RIBBLE VALLEY BOROUGH COUNCIL

Officer:	Laura Eastwood	Direct Tel:	01200 414493	Council Offices Church Walk Clitheroe Lancashire BB7 2RA	
Email:	laura.eastwood@ribblevalley.gov.uk				
Our Ref:	RV/2020/ENQ/00096				
Proposal:	Demolition of dwelling and construction of replacement dwelling.				
Location	Overdale, York Lane, Langho				
Date of site visit	16 th October 2020				
Date of meeting	23 rd October 2020				
Date:	9 th November 2020

Pre-Application Enquiry Response

**Sun Path Analysis**  
**May**  
**Existing**  
53.798872N -2.442115W

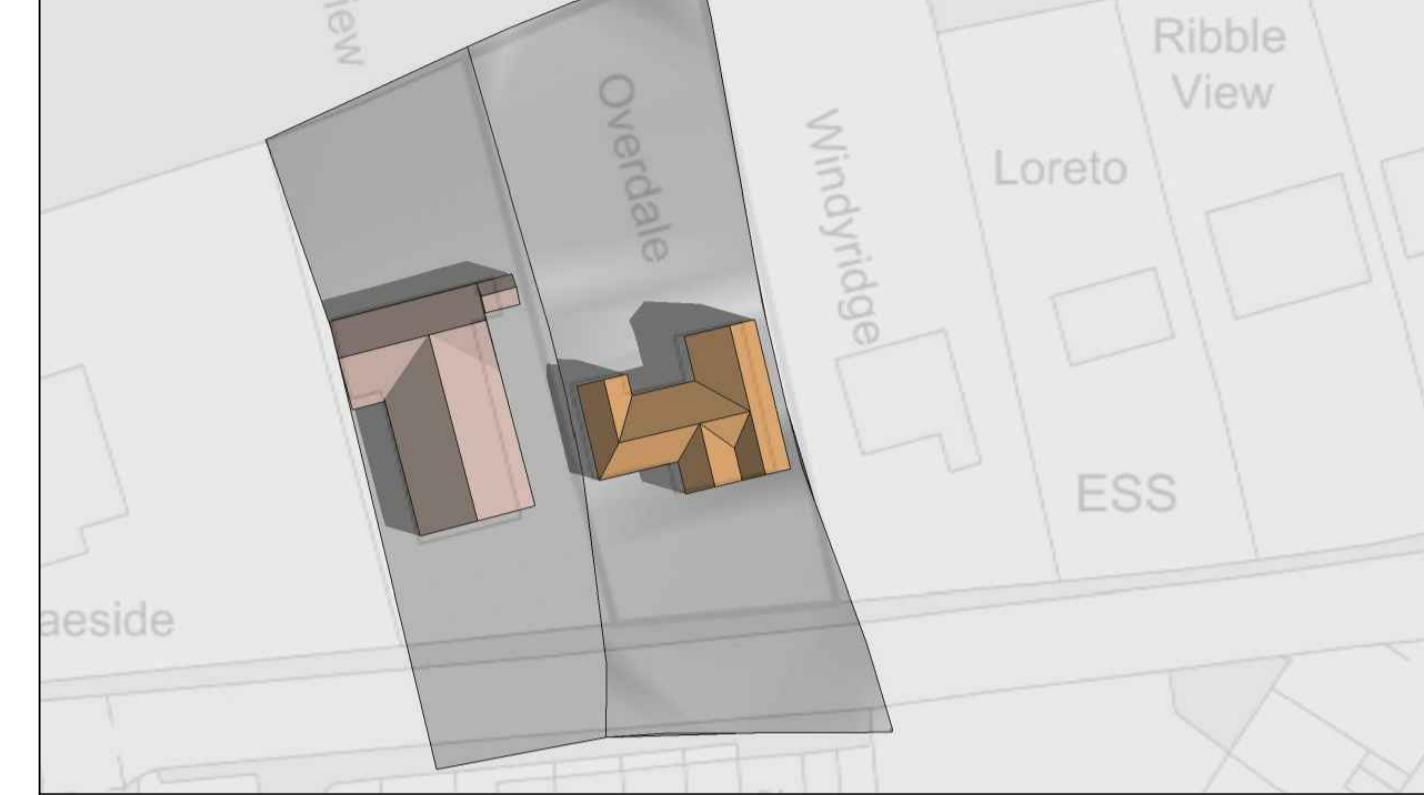
I note that you have amended the scheme following our discussions with regard to the impact on adjacent dwellings, particularly Petre View. The new dwelling will now be set behind their side facing windows so will not be overbearing and the sun path analysis demonstrates that the new building will not overshadow the neighbours to a greater degree than the existing situation. There are no upper floor windows that would directly overlook other properties.

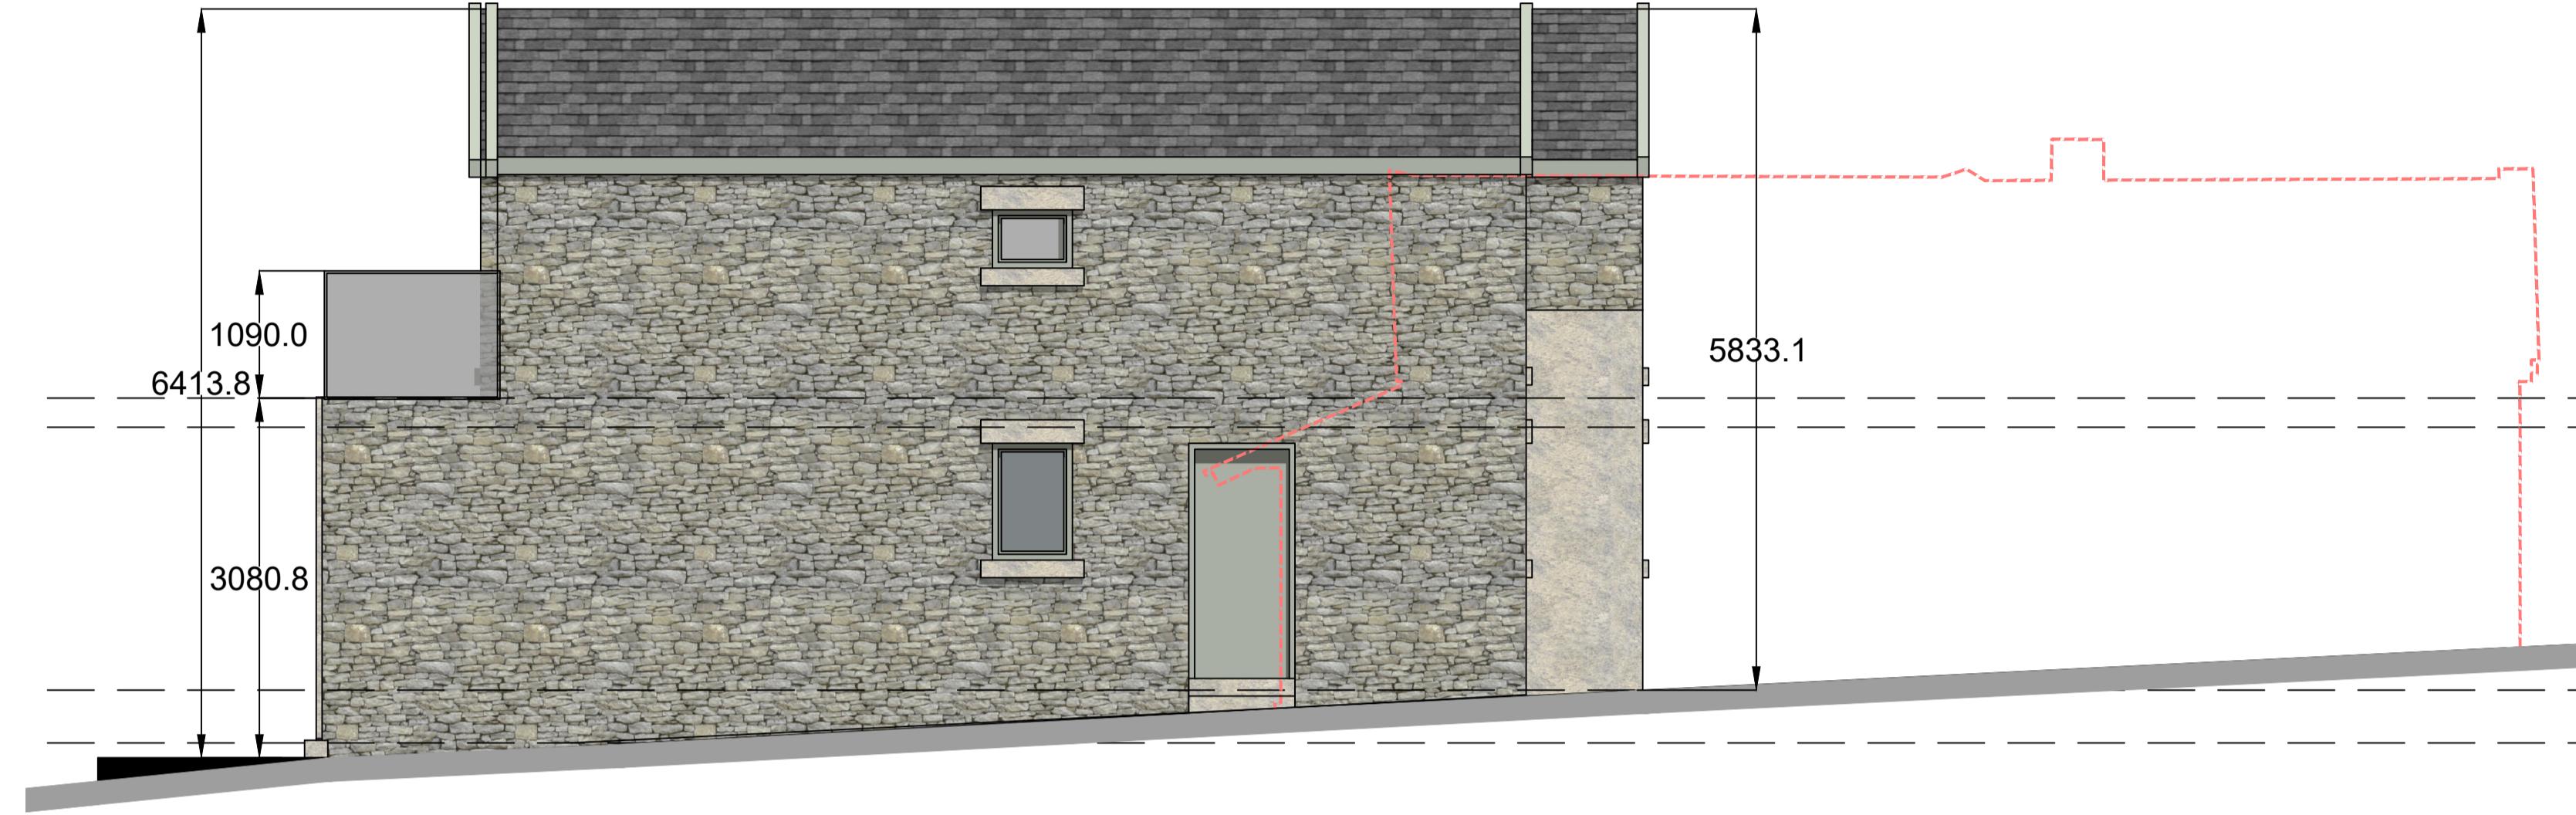
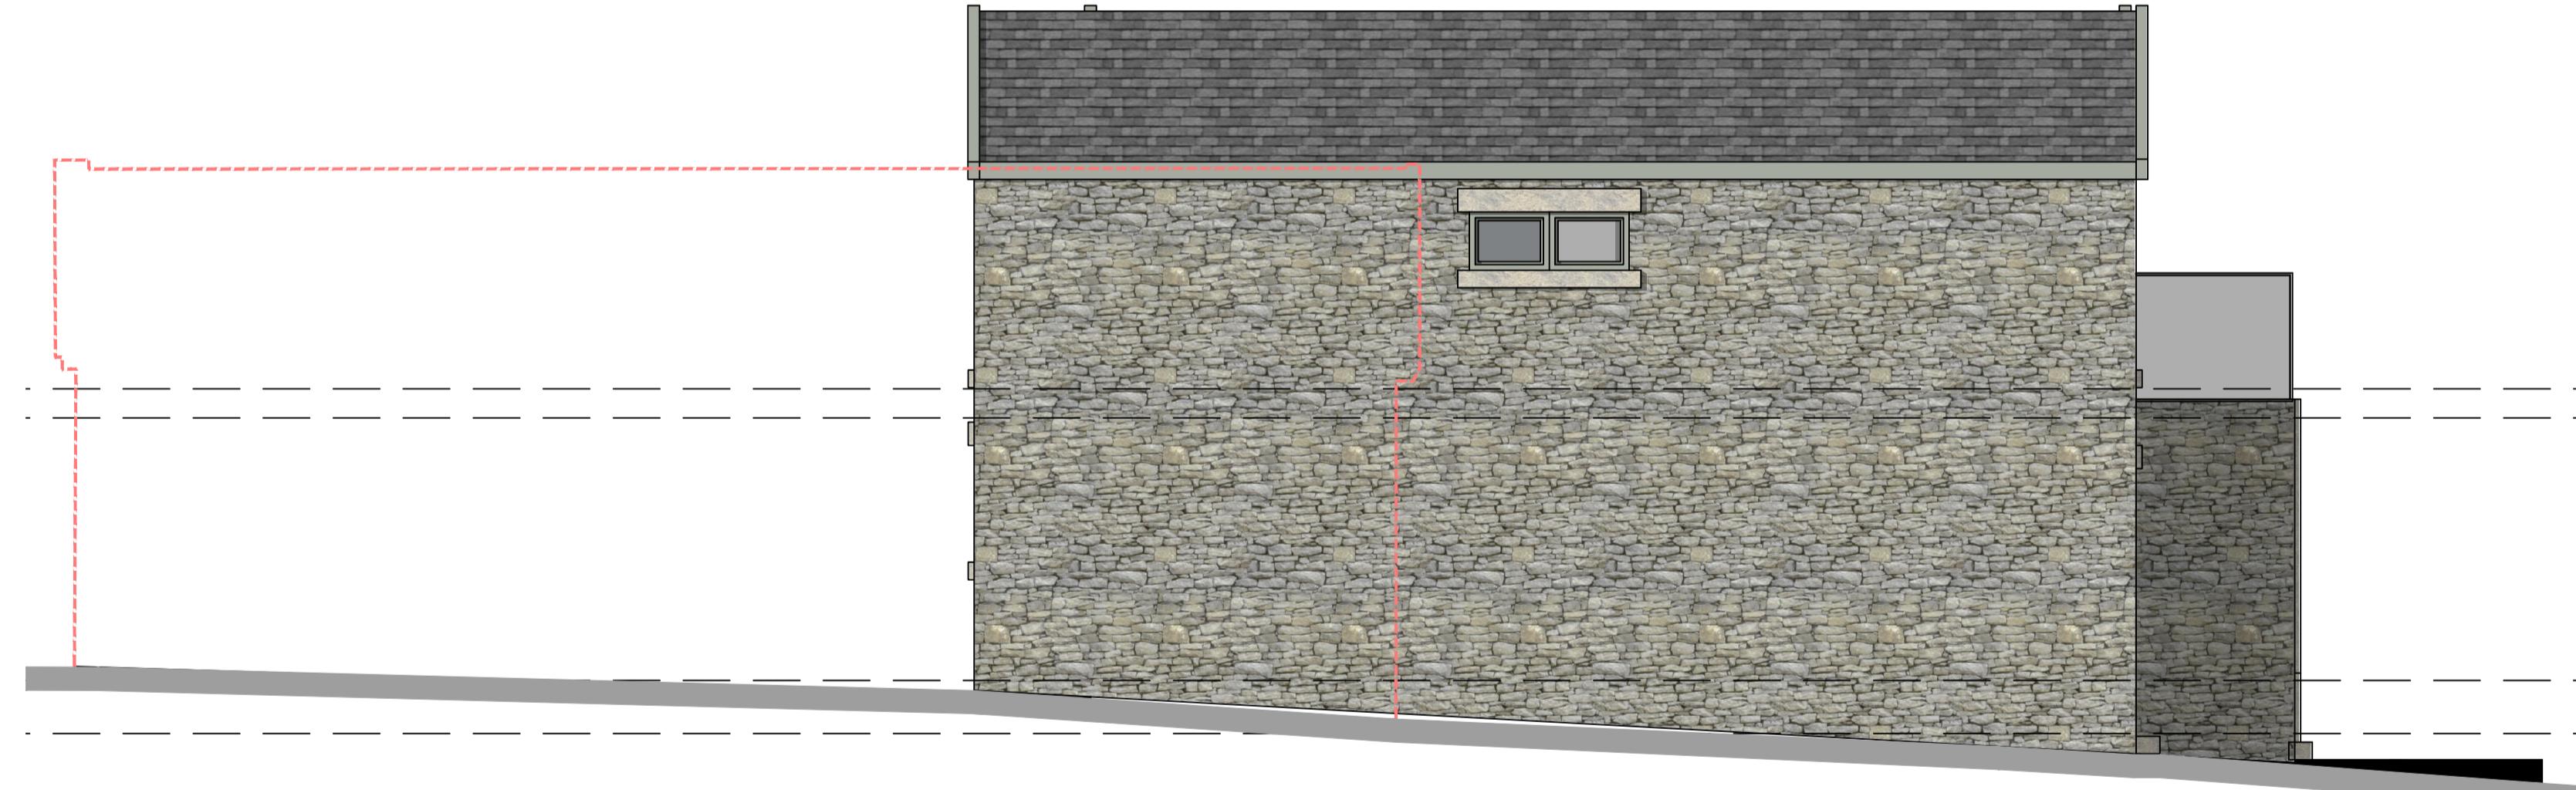
Please note that the utility room door has been omitted from the elevation drawing.

Site Section A

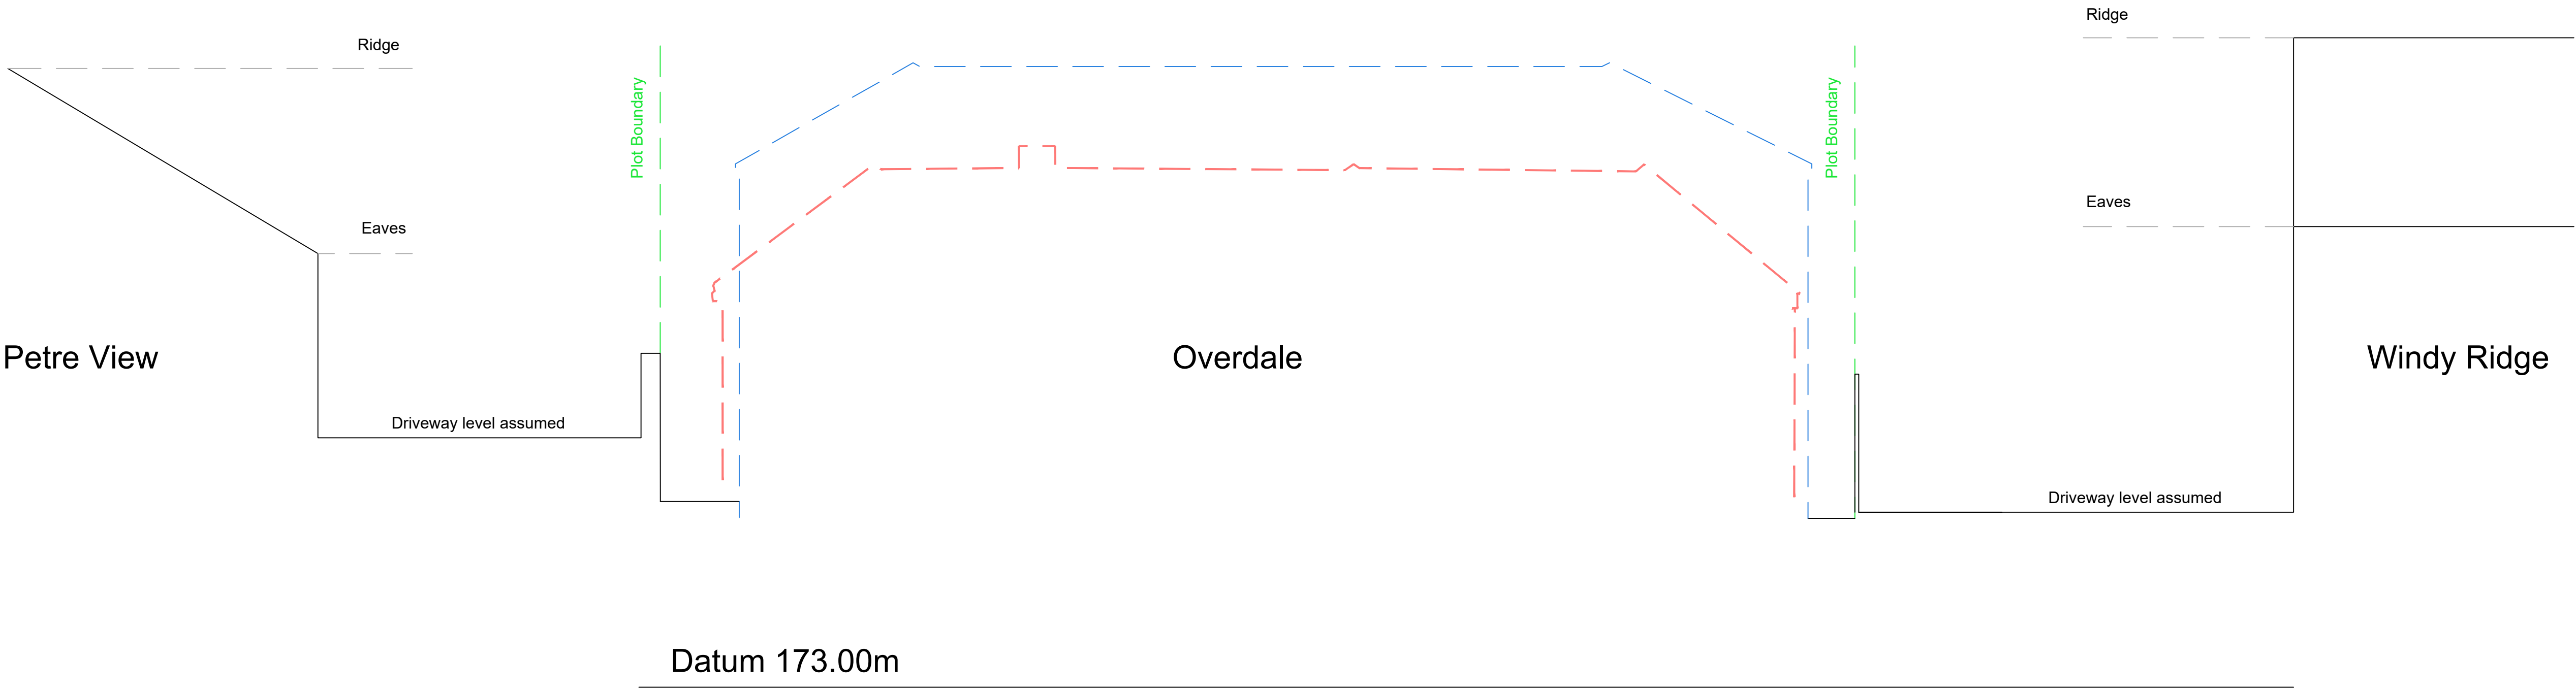
The new dwelling will be a similar footprint and width to the existing. The ridge has been kept as low as possible; forward facing gables and rooflights in the roof slope will allow the roof space to be used for habitable rooms. The new building will be set further back in the site which slopes down away from the road which will reduce its height and impact when viewed from the front.
